**Our ref:** 26\_34259\_P

**Your ref:** H11-1294-25

**Site Location:** 4A Gimmels Gate, Long Sutton,  
Spalding, PE12 9AS

**Summary of Proposal:** Change of Use of  
Storage Shed to Residential - Retrospective

BLOCK PLAN 1:200

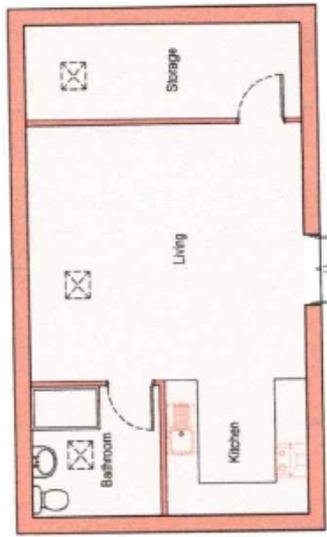
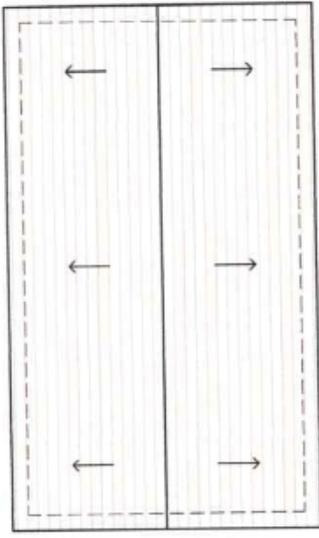
We note the presence of a watercourse which is not maintained by the Board (a riparian watercourse) adjacent to the western site boundary. Whilst not currently proposed, should the applicant's proposals change to include works to alter the riparian watercourse, or if works are proposed to alter the watercourse at any time in the future, consent would be required under the Land Drainage Act 1991 (and Byelaw 4).
